Recommendation Report for Planning Permission for Works or Extension to a Dwelling

REF NO: FP/68/21/HH

LOCATION: 23 First Avenue
Felpham
PO22 7LG

PROPOSAL: Dormer window to side (south) elevation

Drwg. no. 20/12/2^

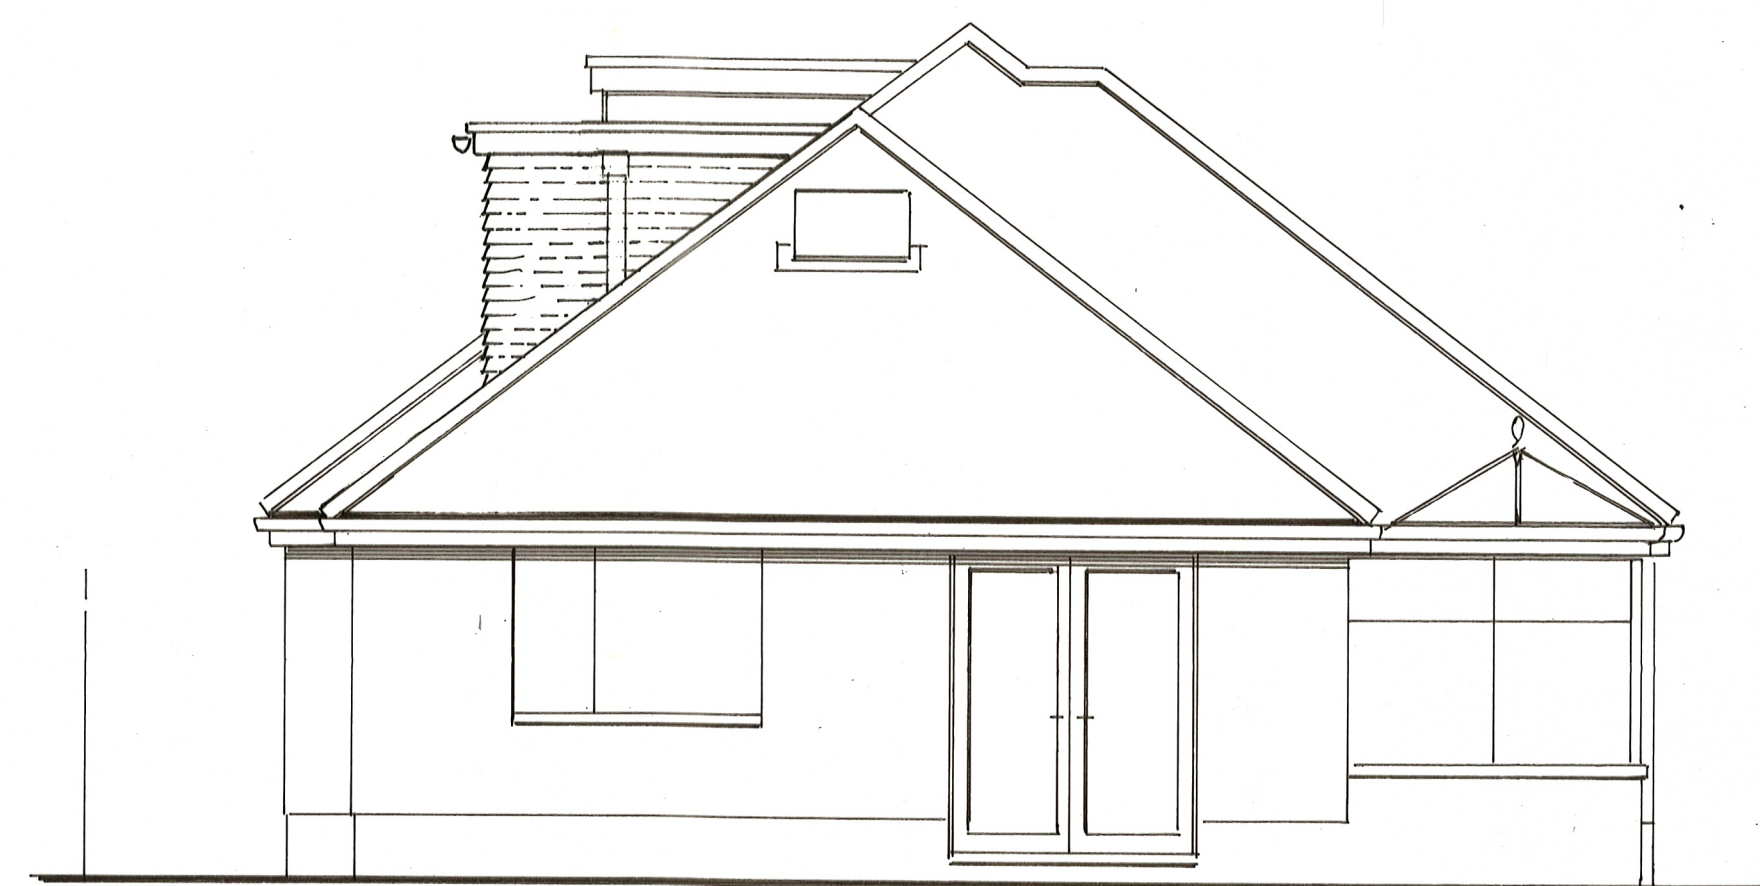
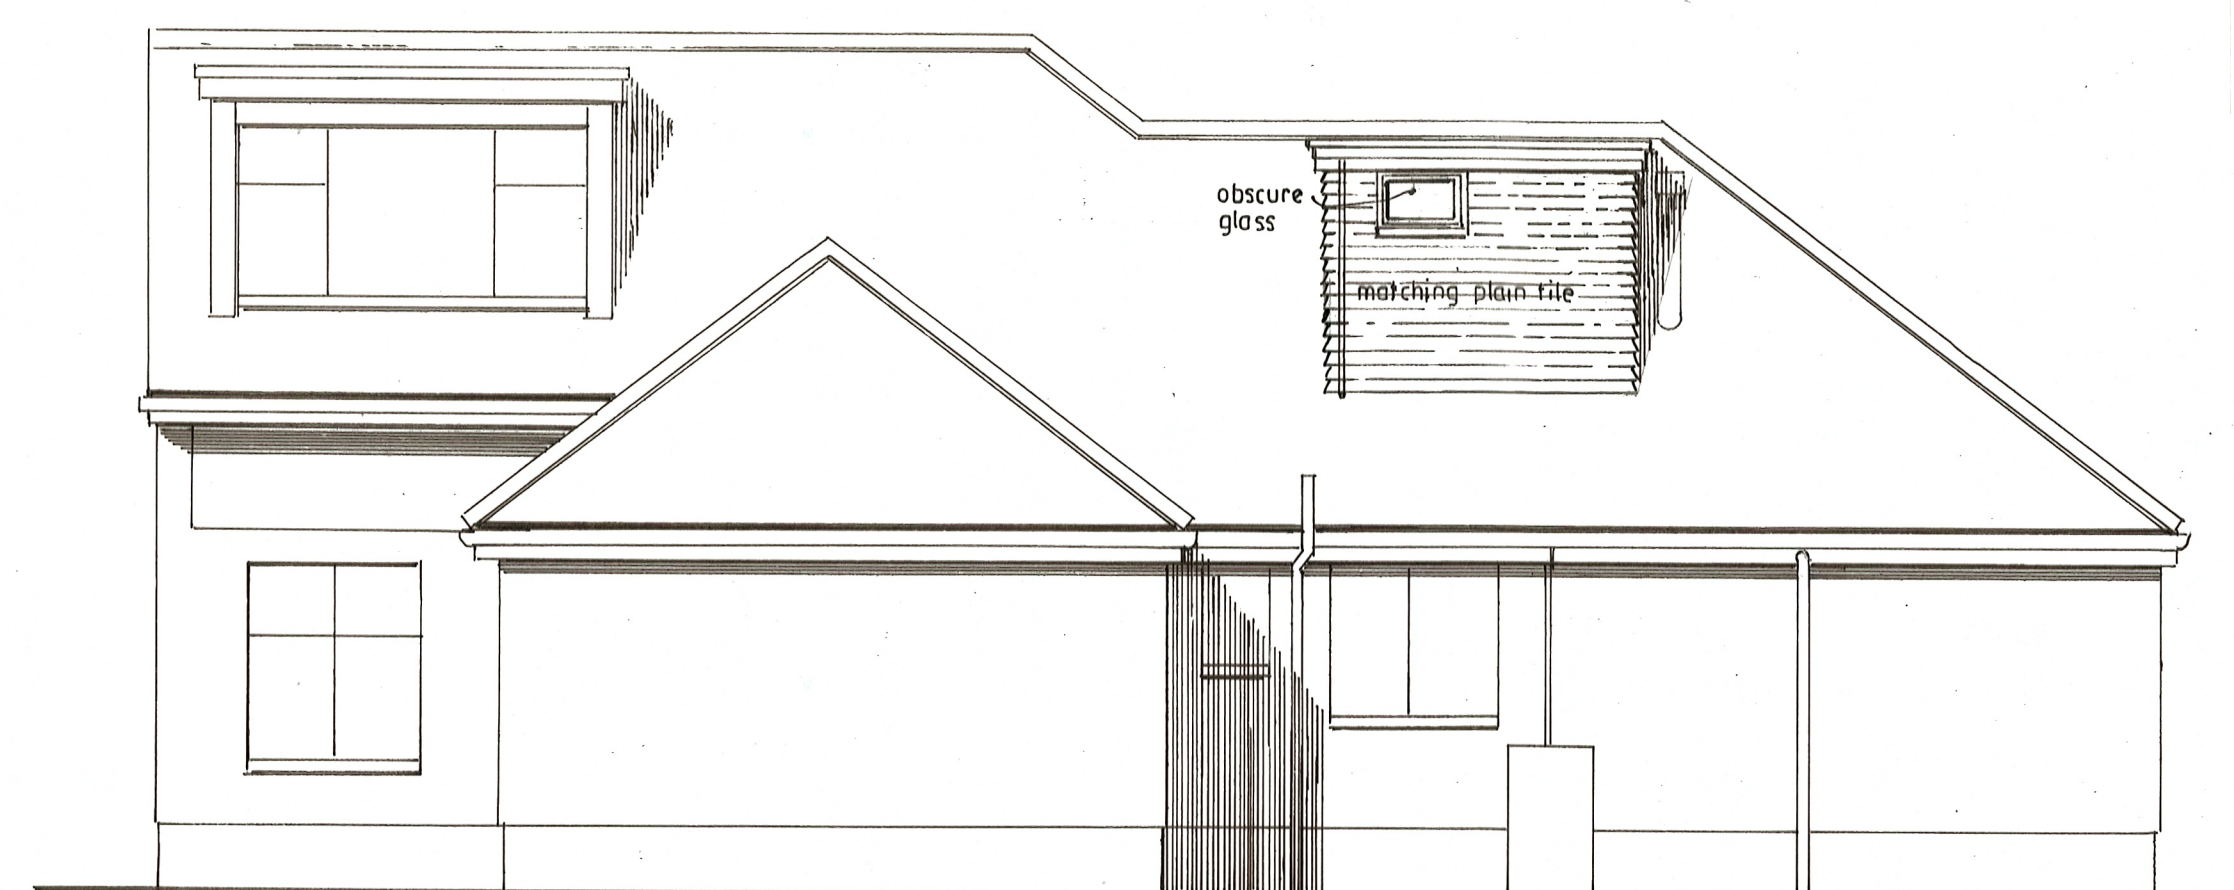
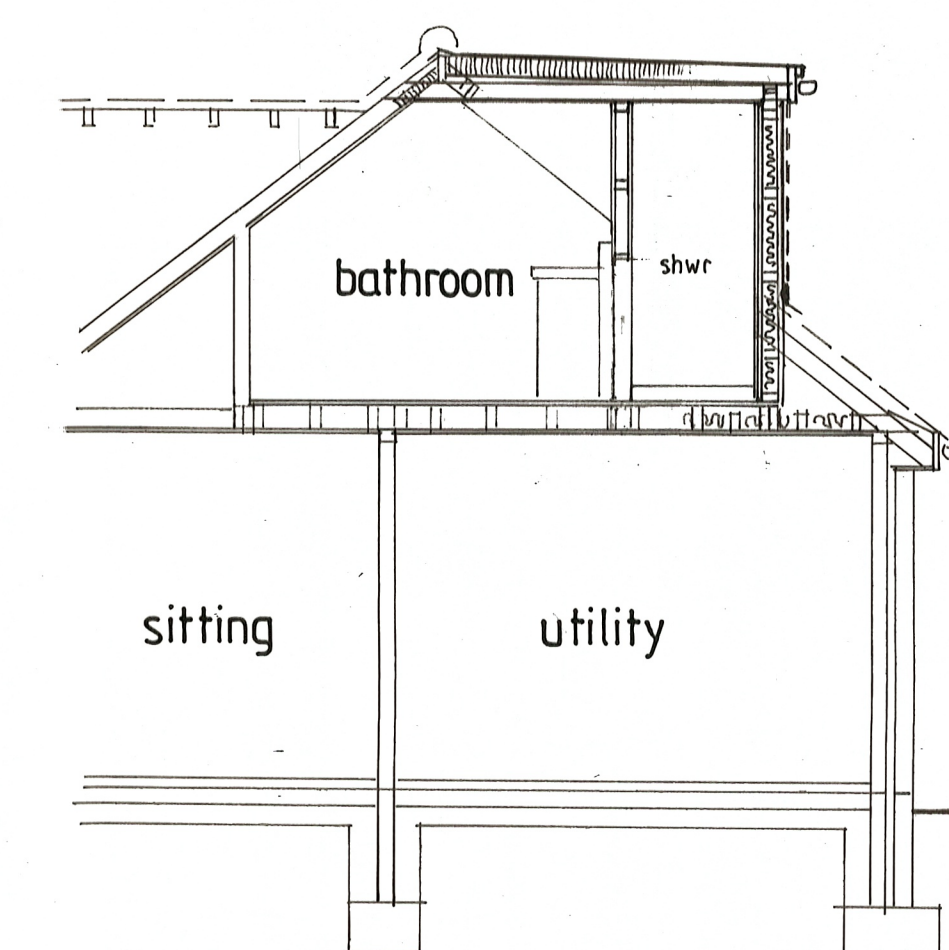
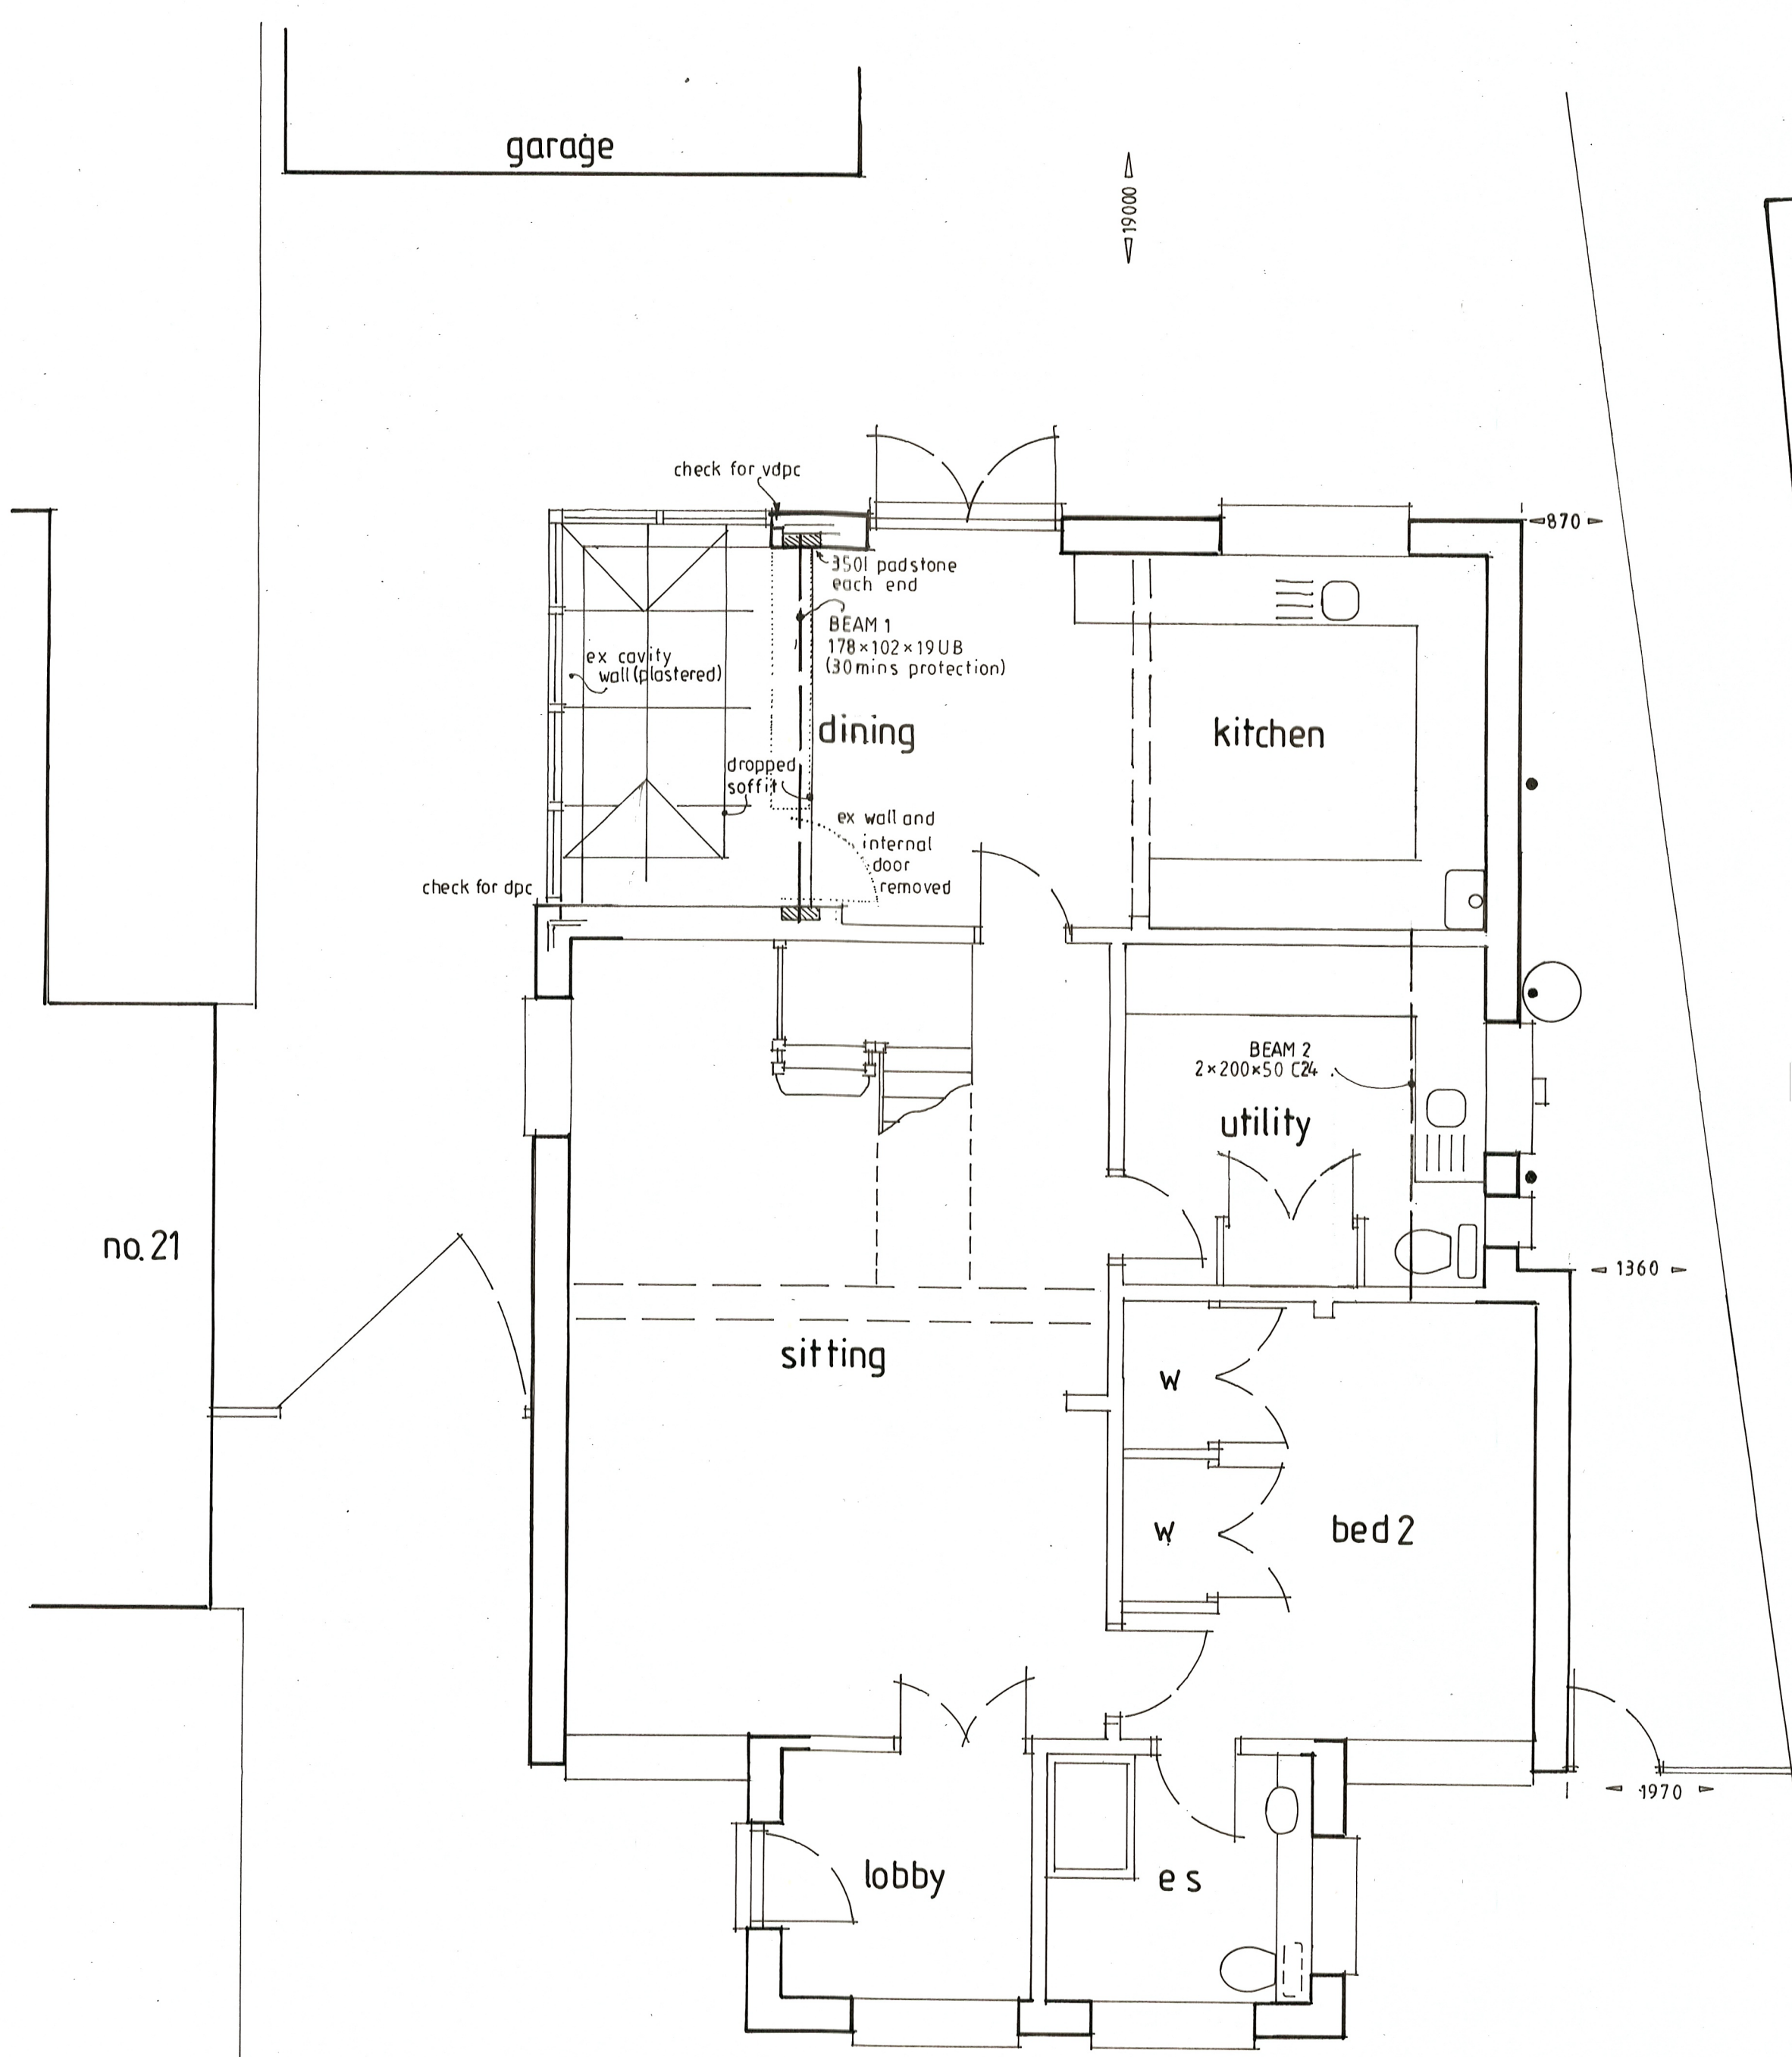
The dormer is modest in size and set back towards the rear end of the property and as such views from the street scene are minor. It will have a depth of around 2.25m and a height of 1.7m.

The dormer will consist of tile hanging which will match that of the host dwelling ensuring it appears well integrated on the roof slope.

The dormer will be situated to the side elevation facing south. The dormer is located towards the rear of the side elevation and will face the neighbouring property at No.25. There is 1 window to the first floor side elevation to the neighbouring property which serves a bathroom and it is not considered to the dormer would give rise to adverse overlooking. The dormer does however serve a bathroom and the plans have noted the window will remain obscured glazed. This will be conditioned and will ensure that the dormer will not give rise to adverse views upon the neighbouring property.

Reason: For the avoidance of doubt and in the interests of amenity and the environment in accordance with policy D DM1 of the Arun Local Plan.
- 3 The first floor dormer window on the southern elevation of the building shall at all times be glazed with obscured glass.
